Item No. **Report of the Head of Planning, Sport and Green Spaces**

Address 20 BUCKINGHAM GROVE HILLINGDON

Development: Conversion of roof space to habitable use to include a rear dormer and 2 front roof lights

LBH Ref Nos: **70445/APP/2014/4130**

PROPOSED PLANS & ELEVATIONS.

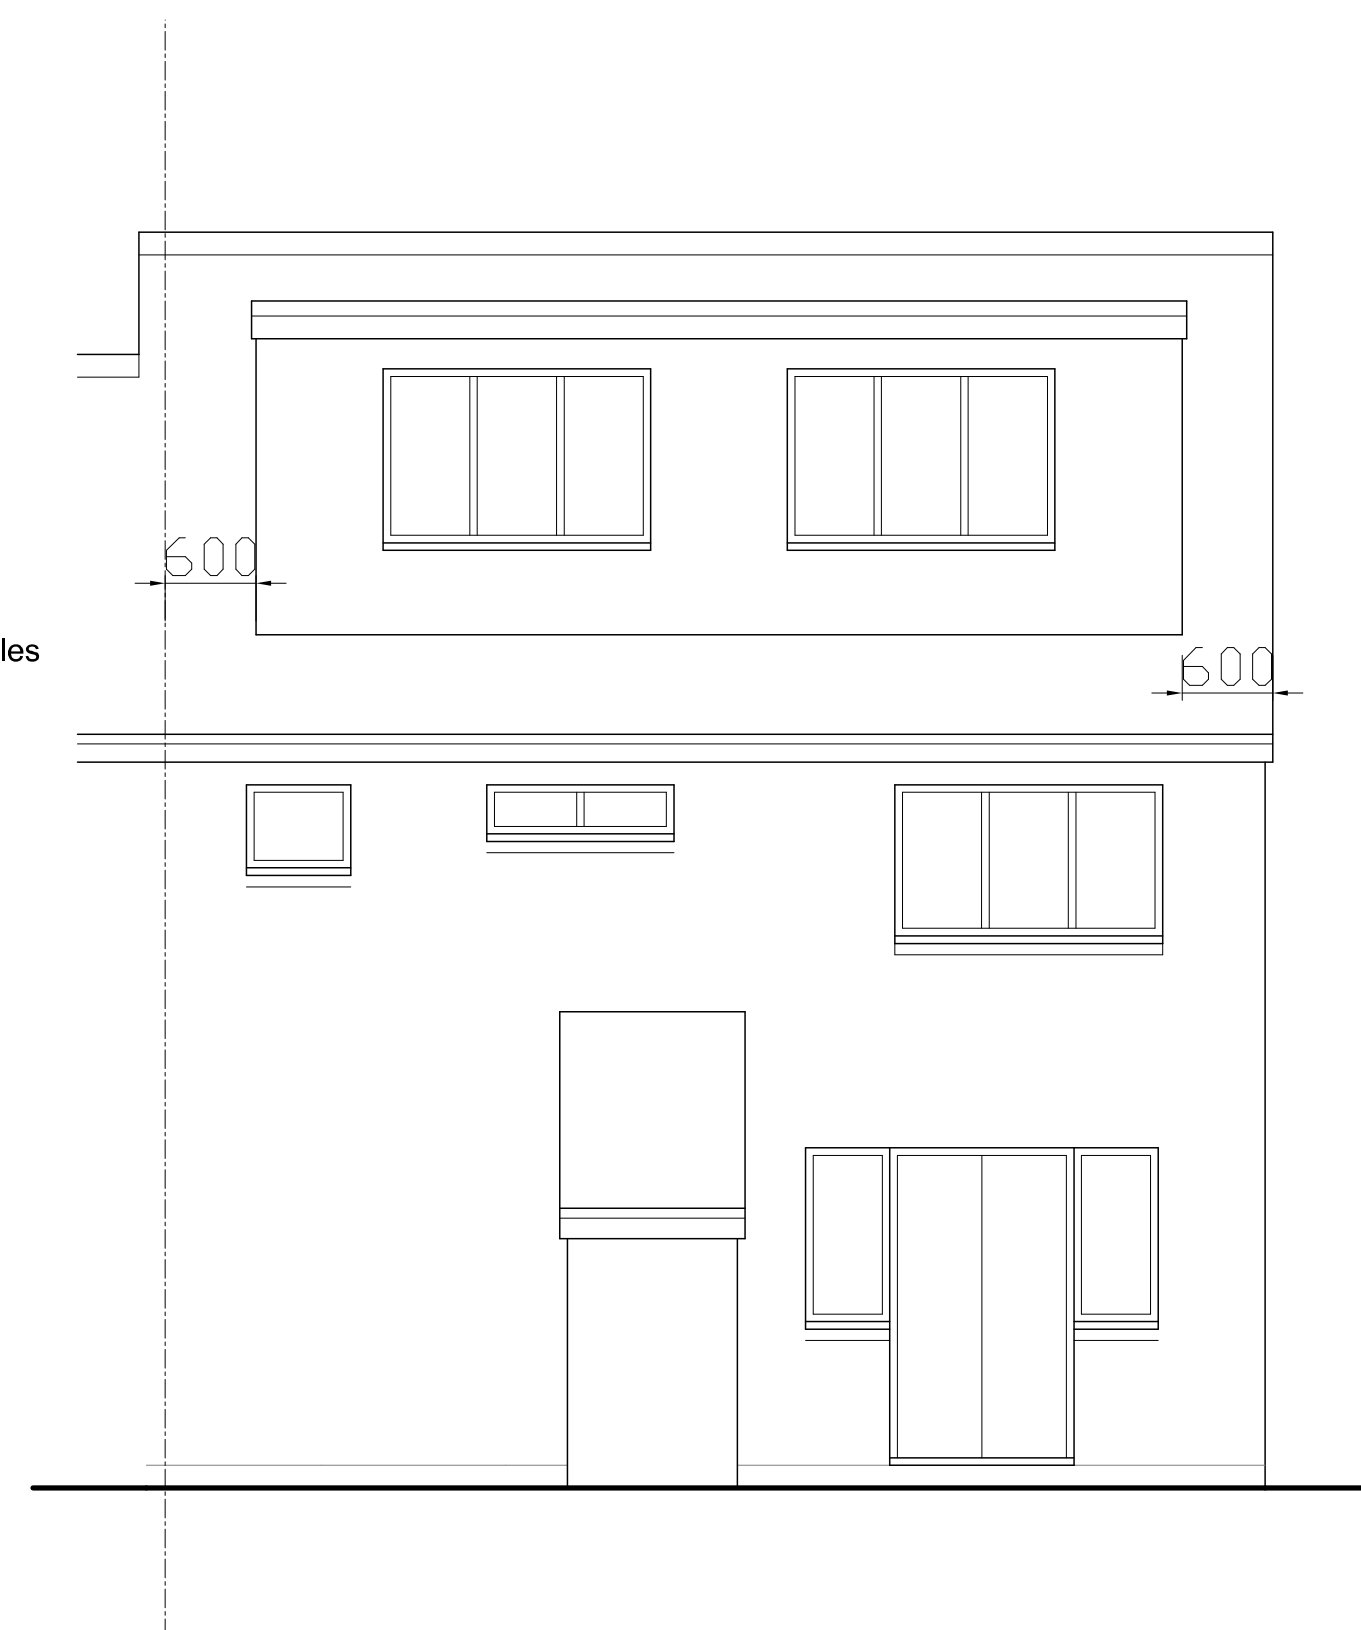
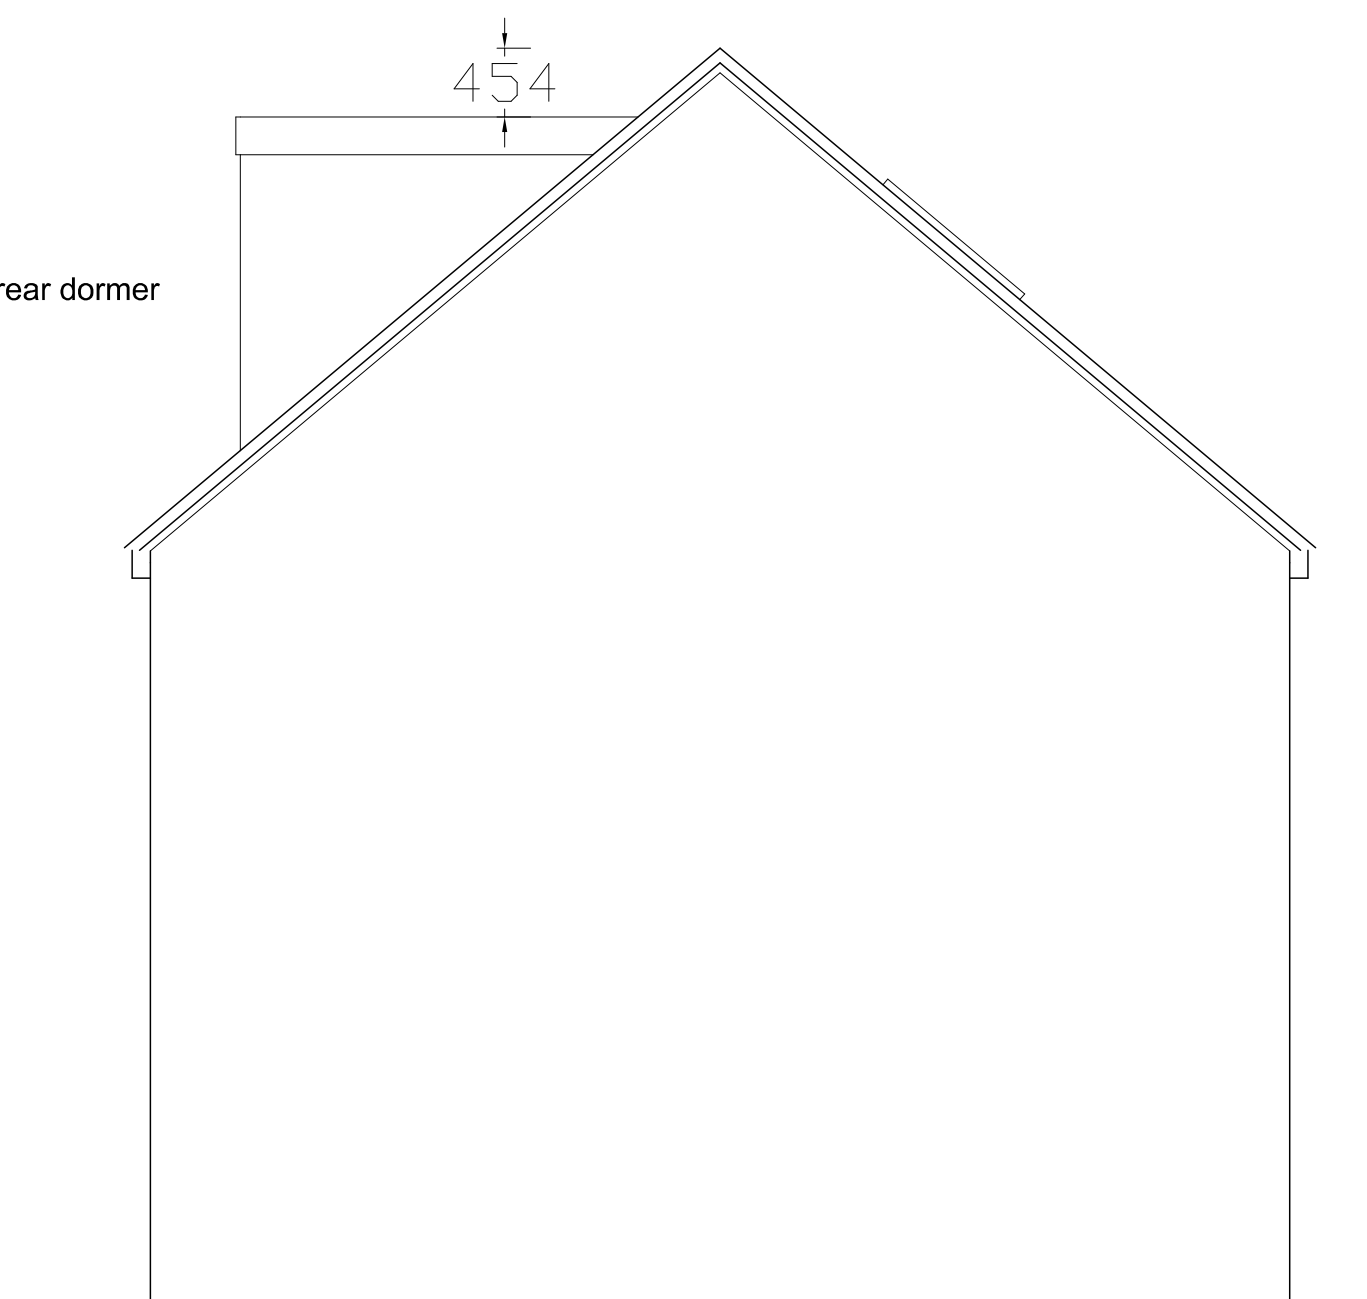
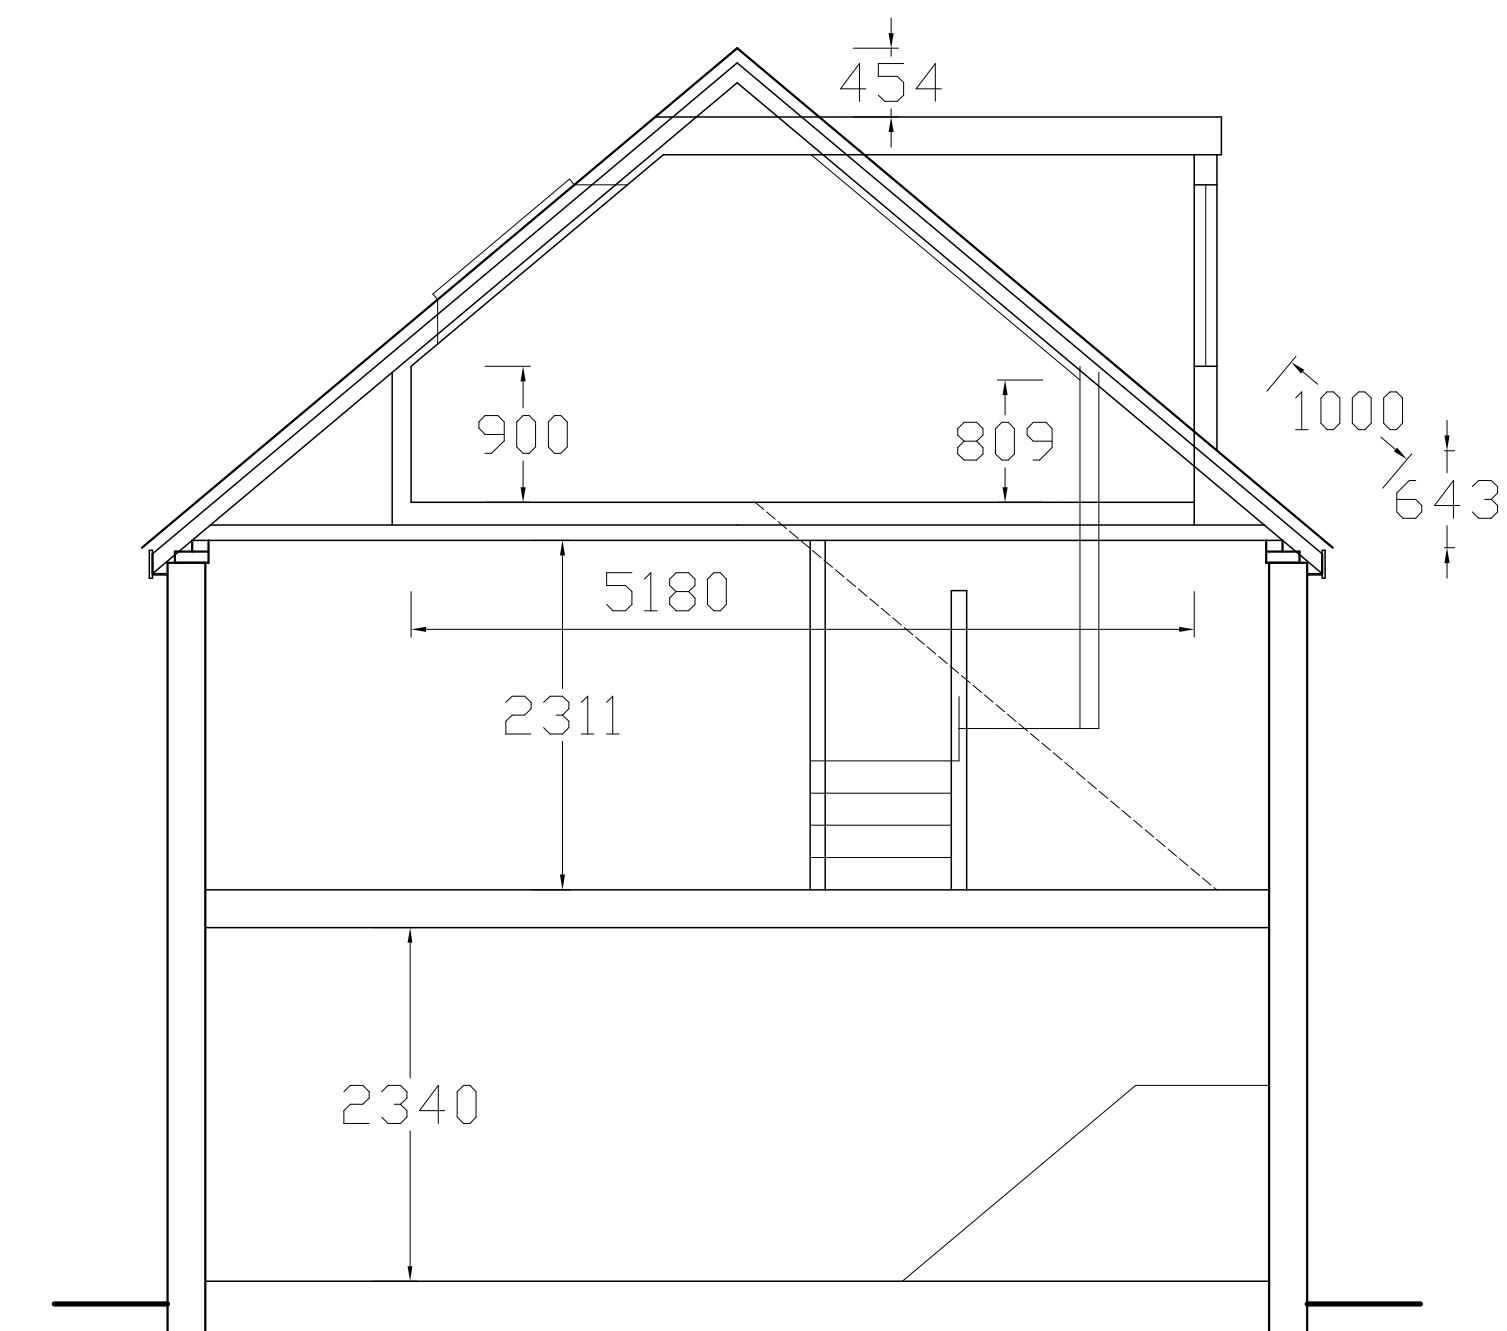
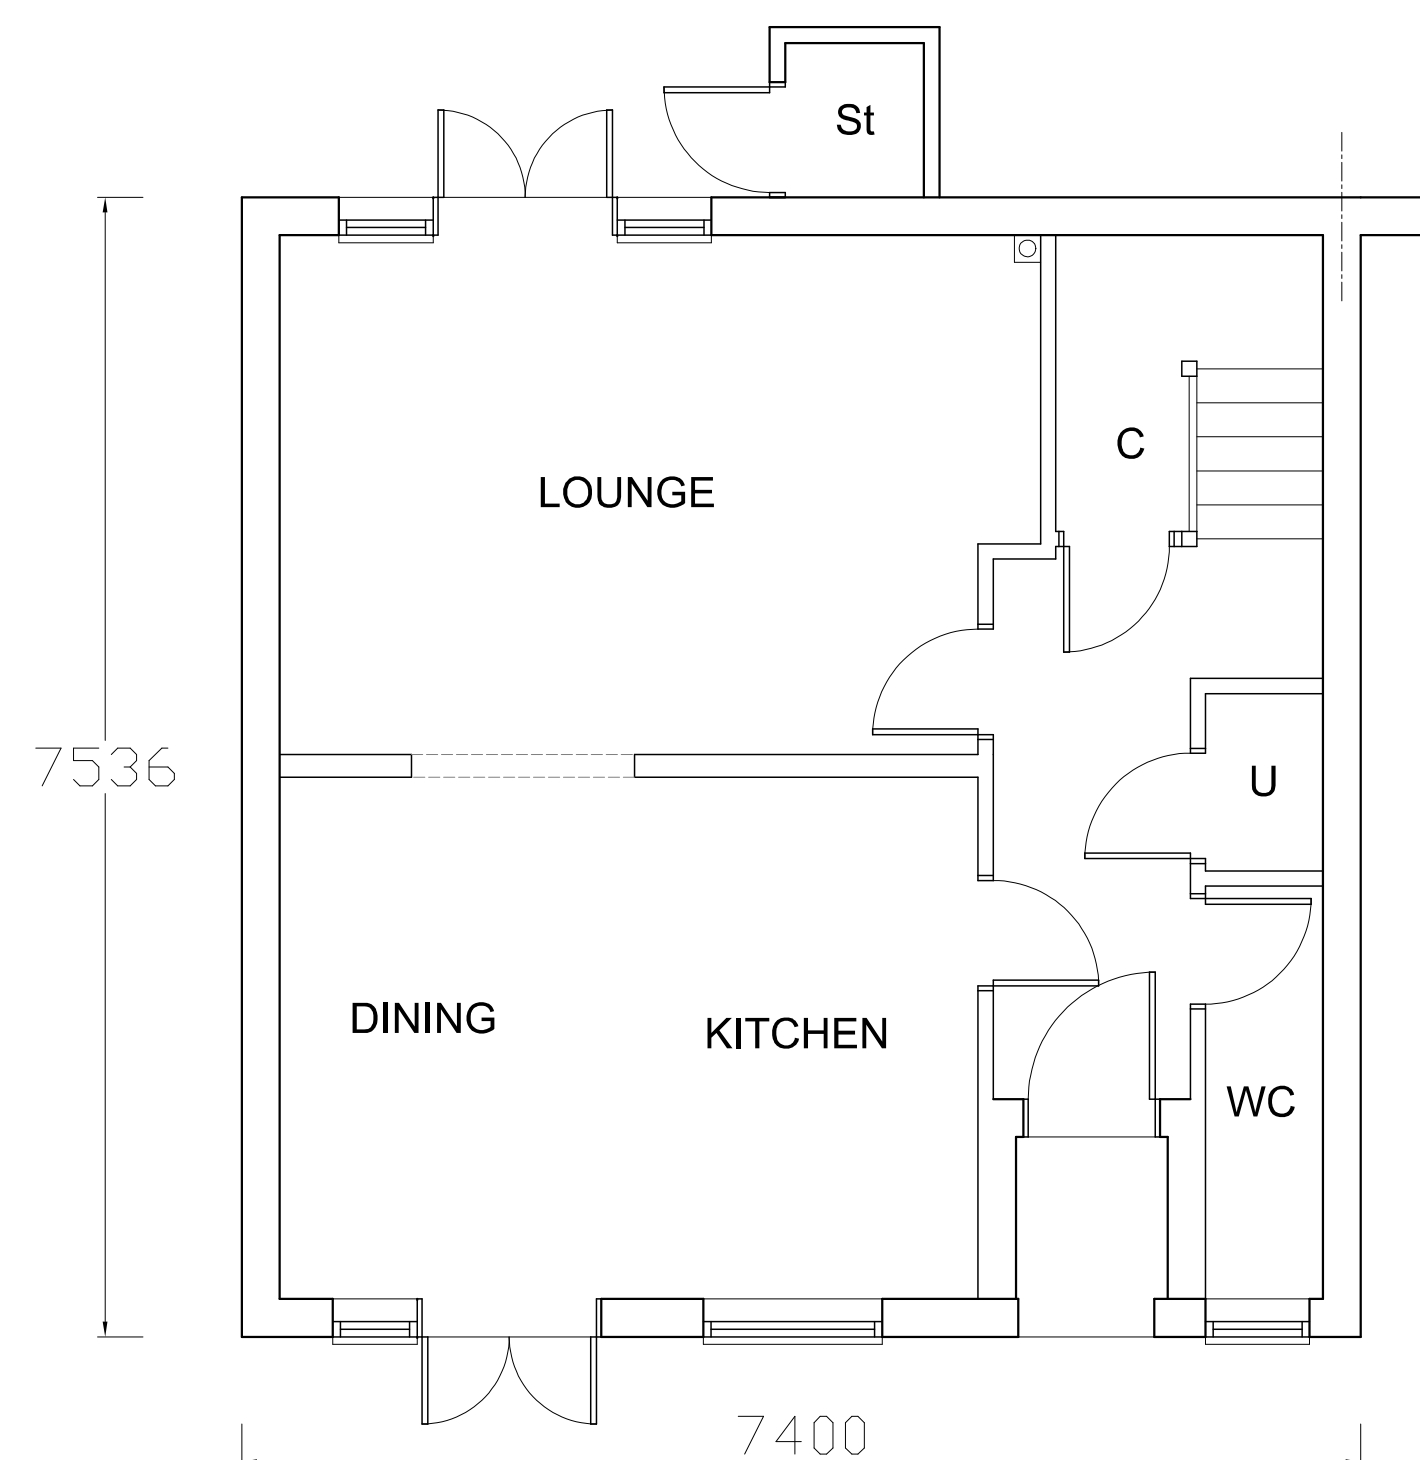
COMMENTS: Taking into account the style of the terraced properties, the proposed dormer would not be in keeping with the character of the surrounding area, and would be highly visible from the public access way and other visible aspects due to the orientation of the property. The proposed dormer would be considered an over large incongruous addition, creating an unnecessary precedent.

The front roof lights would need to be of the conservation flush-type.

Whilst the proposed dormer window would comply with the advice set out in section 7 in terms of its size and set down of the HDAS Guidance, it would still result in a very large dormer dormer which would dominate the roof slope within which it would be set. Concerns are also raised in terms of its impact upon this property and the wider Hillingdon Village Conservation Area. Whilst the dormer is set in the rear roof slope, the rear of the site is an open area with a number of footways crossing it. The rear elevation is extremely prominent. The Council's Conservation Officer has advised that "Taking into account the style of the terraced properties the proposed dormer would not be in keeping with the character of the surrounding area, and would be highly visible from the public access way and other visible aspects due to the orientation of the property. The proposed dormer would be considered an over large incongruous addition, creating an unnecessary precedent." As such it is considered that the dormer window, by virtue of its excessive size, scale, and bulk and siting in the prominent rear roof slope, would detract from the architectural integrity of the host dwelling and result in an incongruous form of development within the street scene which lies within the Hillingdon Village Conservation Area. Therefore the proposal would be contrary to Policies BE1 and HE1 of the Hillingdon Local Plan: Part One - Strategic Policies (November 2012), Policies BE4, BE13, BE15 and BE19 of the Hillingdon Local Plan: Part Two - Saved UDP Policies (November 2012) and the adopted Supplementary Planning Document HDAS: Residential Extensions.

The proposed dormer window, by virtue of its size, scale, bulk, design and siting in a prominent position, would detract from the architectural integrity of the host dwelling and result in an incongruous form of development, to the detriment of the visual amenity of the street scene and the wider Hillingdon Village Conservation Area. Therefore the

- 1 The applicant is advised, for the avoidance of doubt, that the annotation provided on submitted plans references: MB/3028/1 and MB/3028/2 is incorrect in terms of the front and rear elevation. However the application has been assessed on the basis of the intention of the plans.

SECOND FLOOR PLAN

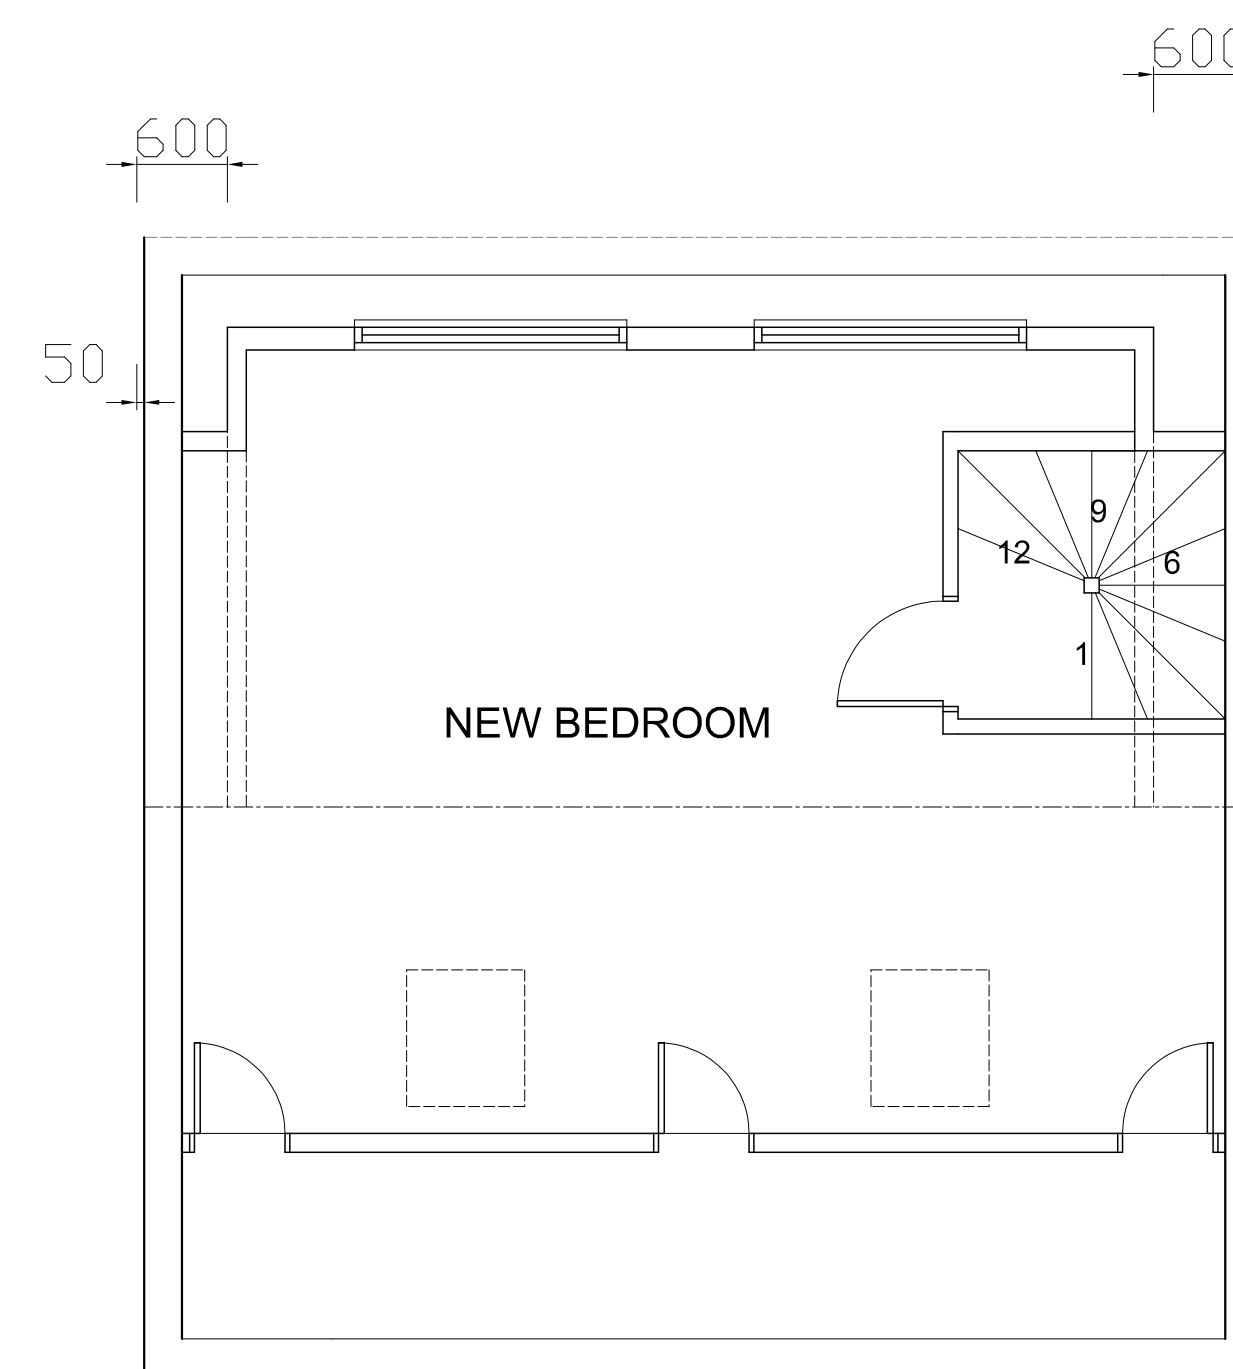
The private rear garden area has remained the same. However the proposal includes a fourth bedroom which increases the requirement to 100m². The private garden area measures 50m² which would result in a considerable shortfall of the HDAS Requirement and as such is considered unacceptable and in conflict with Policy BE23 of the Local plan.

The proposed conversion of the roof space to habitable use would, by virtue of its failure to maintain an adequate amount of private usable external amenity space for the occupiers of the extended property, result in over-development of the site detrimental to the residential amenity of existing and future occupiers. The proposal is therefore contrary to policies BE19 and BE23 of the Hillingdon Local Plan: Part Two - Saved UDP Policies (November 2012) and the adopted Supplementary Planning Document HDAS: Residential Extensions.
